Our Case Number: ABP-317742-23

Re: BusConnects Bray to City Centre Core Bus Corridor Scheme
Bray to Dublin City Centre.

ABP case ref: 317742

BUSCONNECTS BRAY CORE BUS CORRIDOR SCHEME

Drawing Title: BRAY TO CITY CENTRE SCHEME UCD BUS INTERCHANGE GENERAL ARRANGEMENT

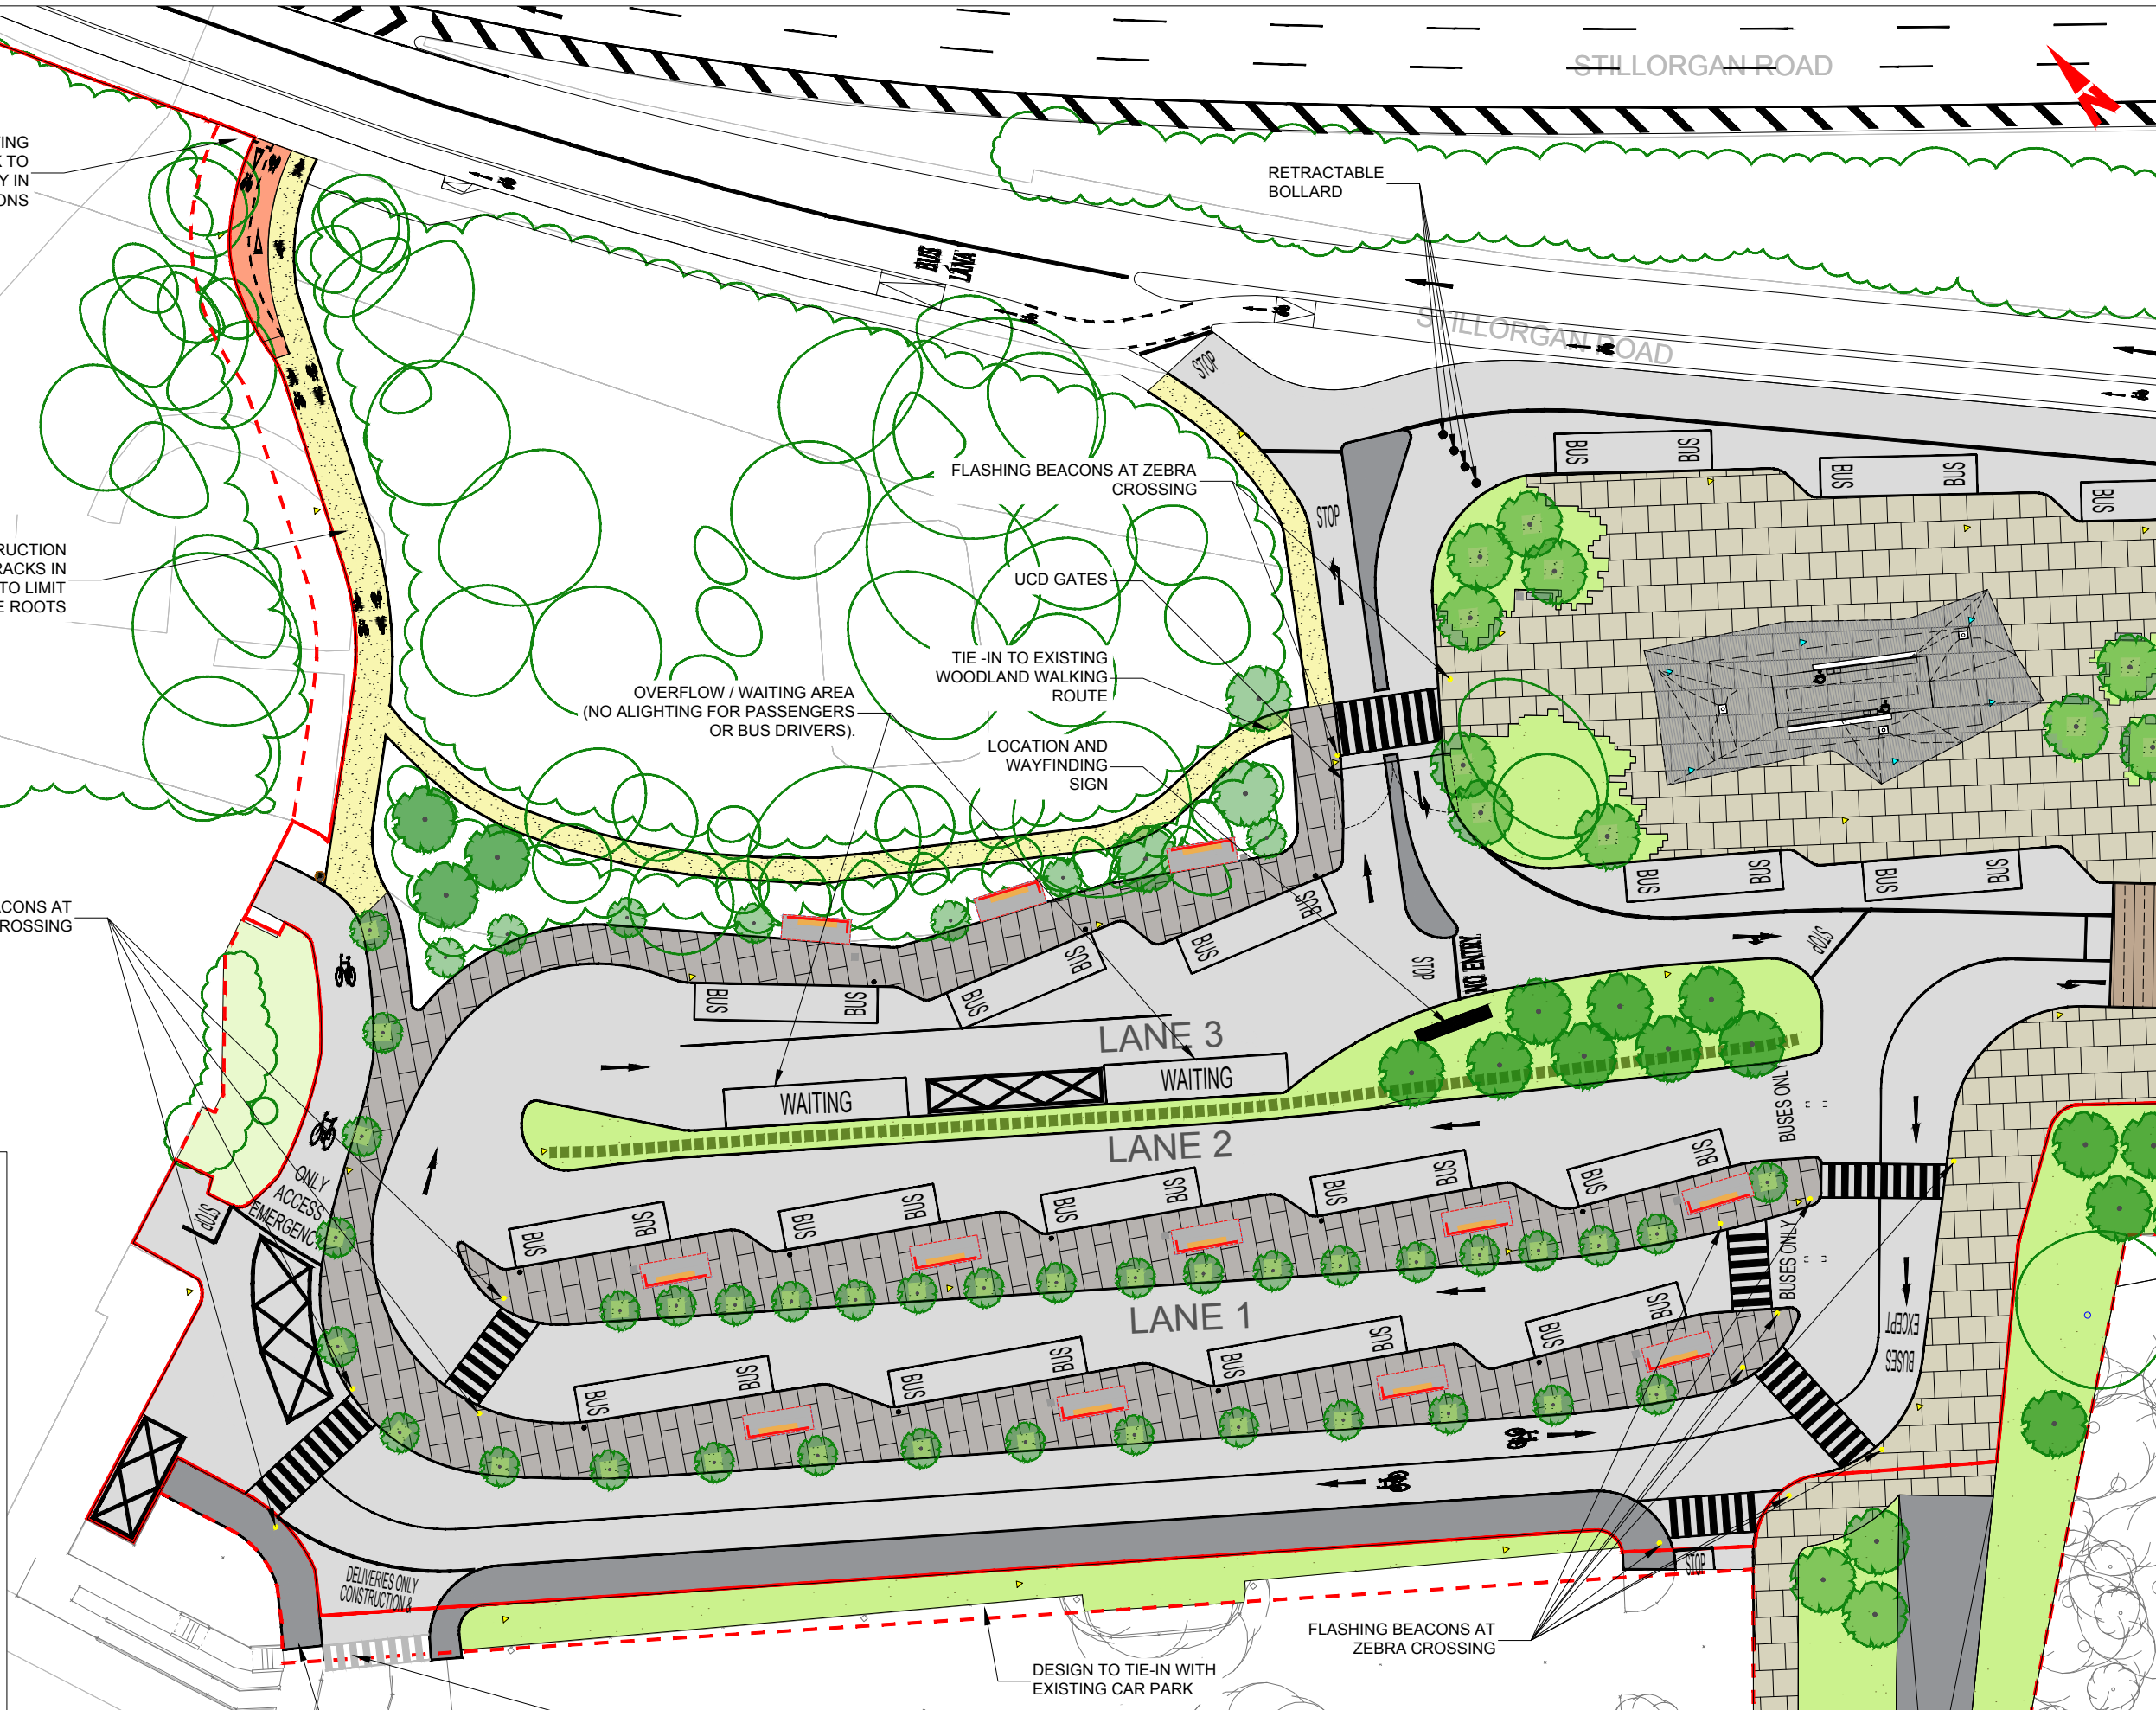
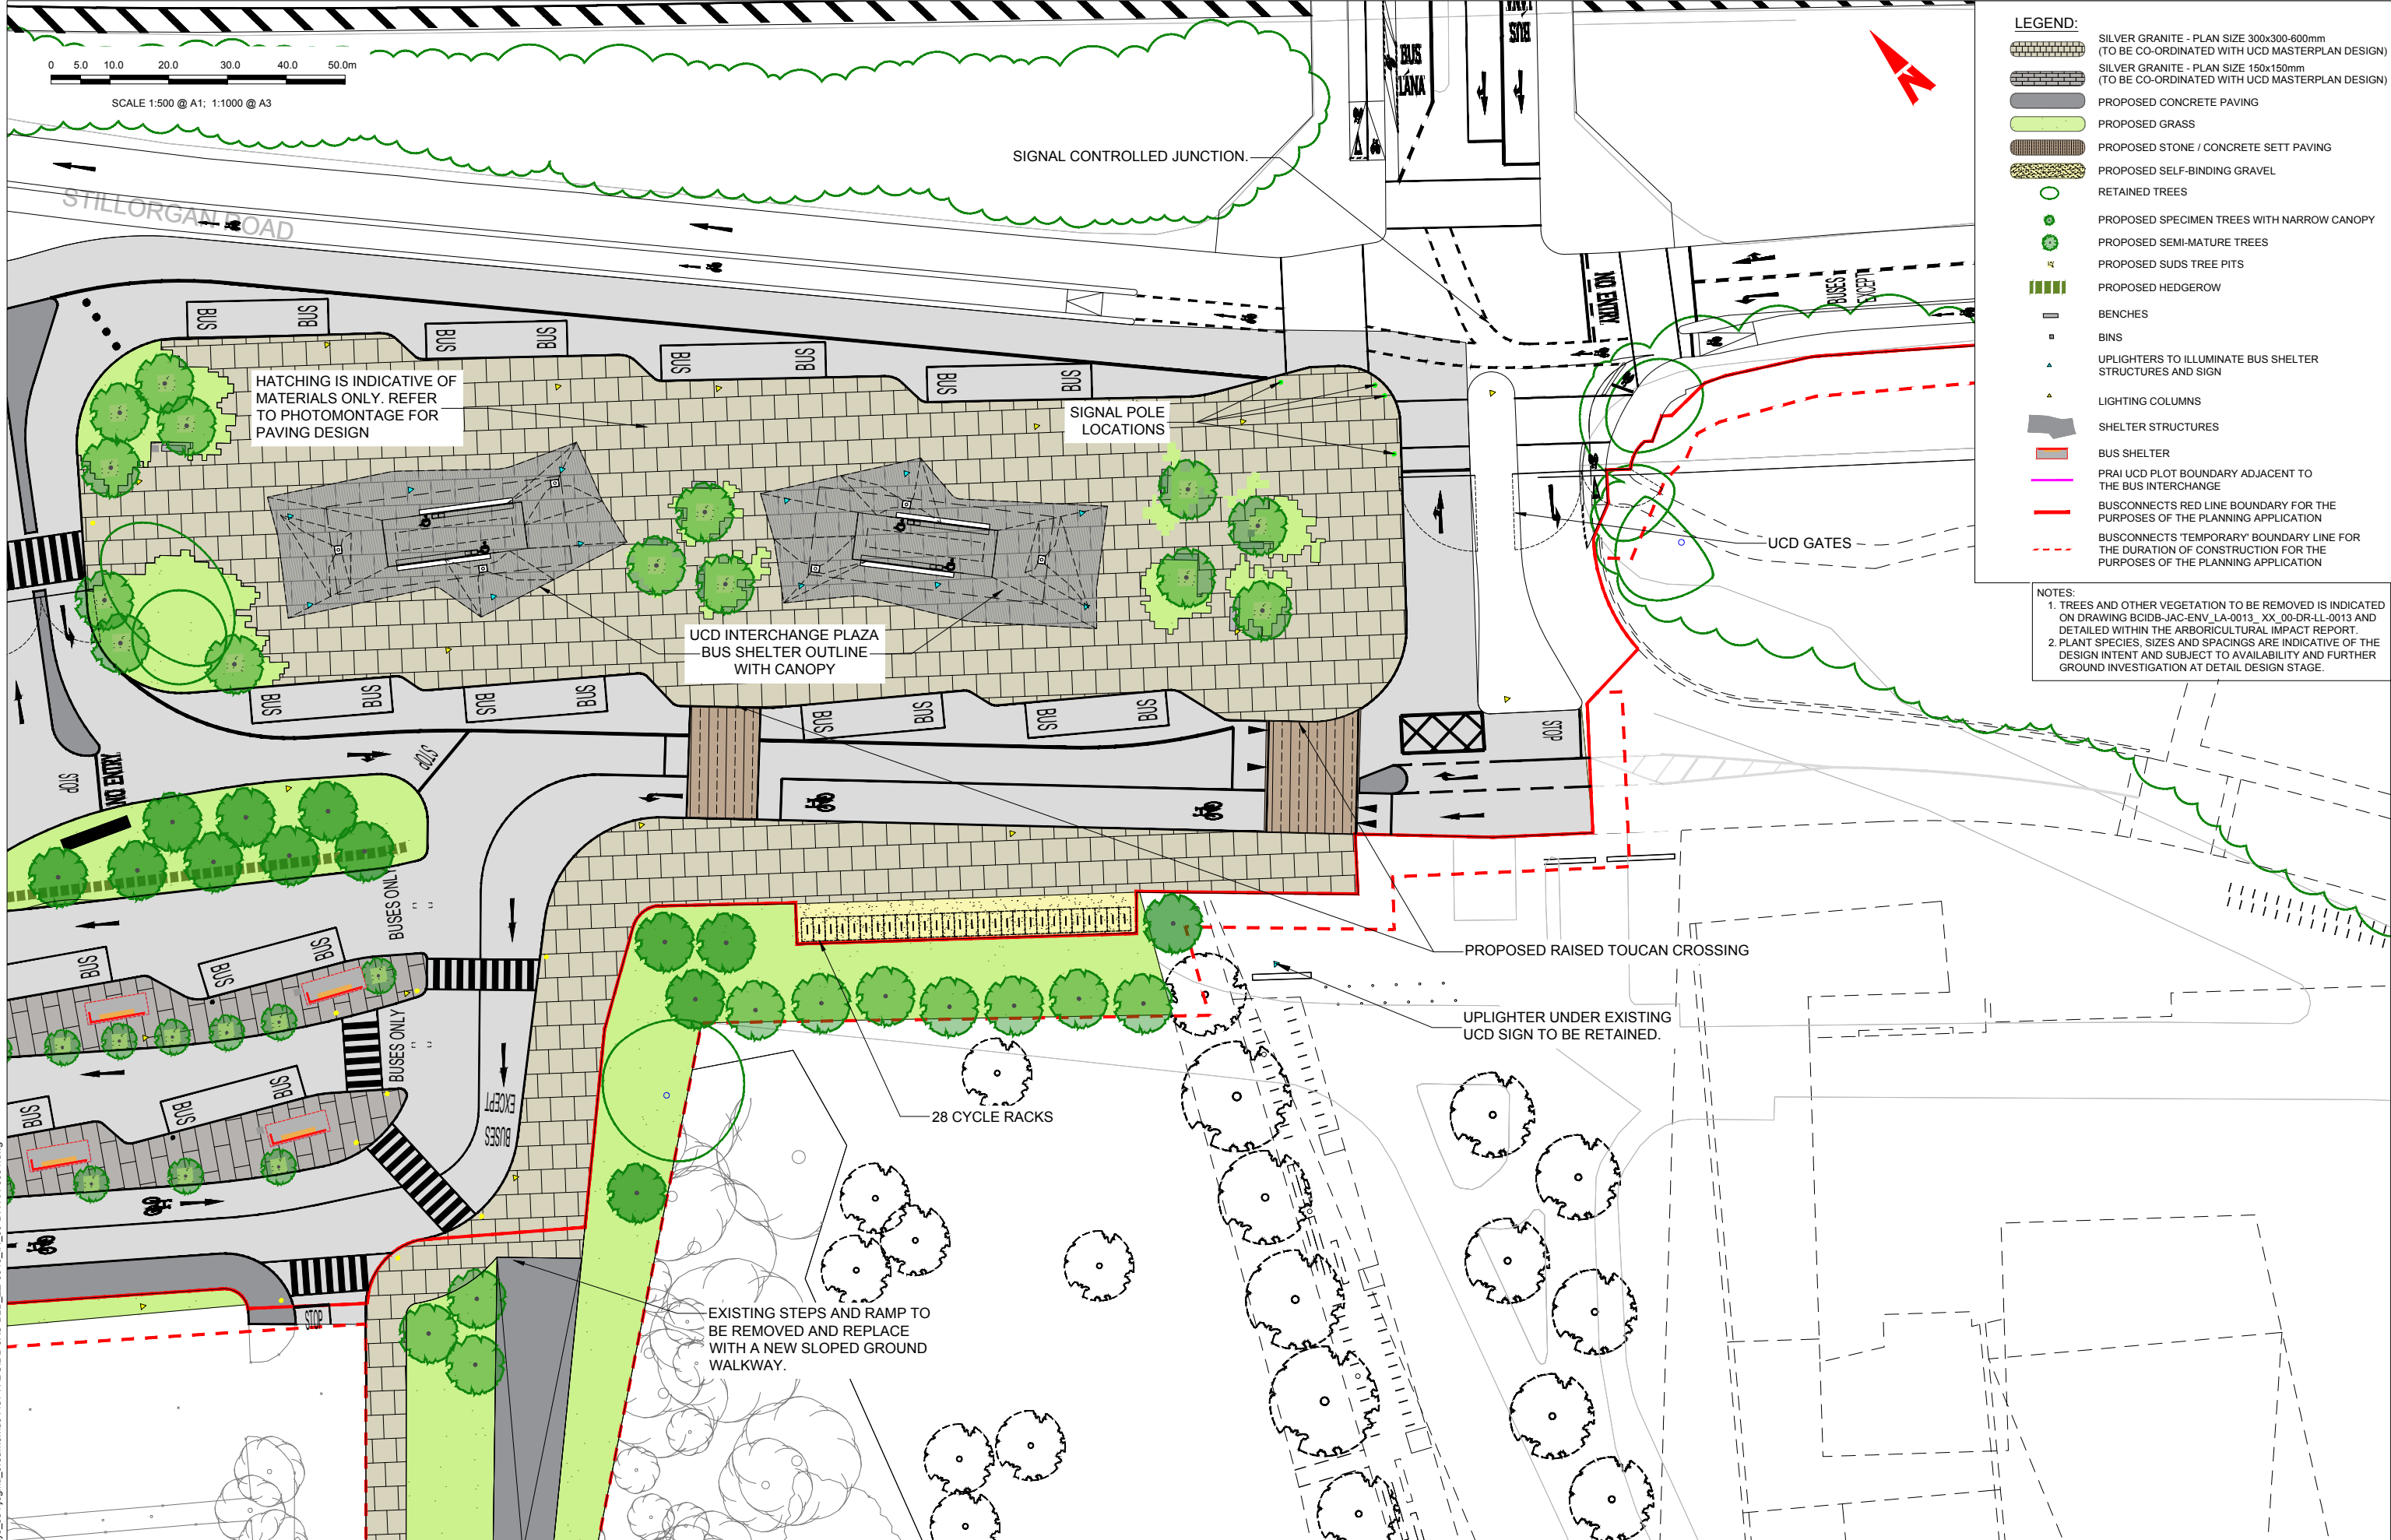
The interface between cycling and buses at the proposed UCD bus interchange is not safe for all ages and abilities. This is a key section of the route for enabling

cycling among the large student population in UCD but the current design proposes buses crossing a section of unsegregated cycle lane. We ask that the Applicant redesign this section and provide full segregation between buses and cyclists.
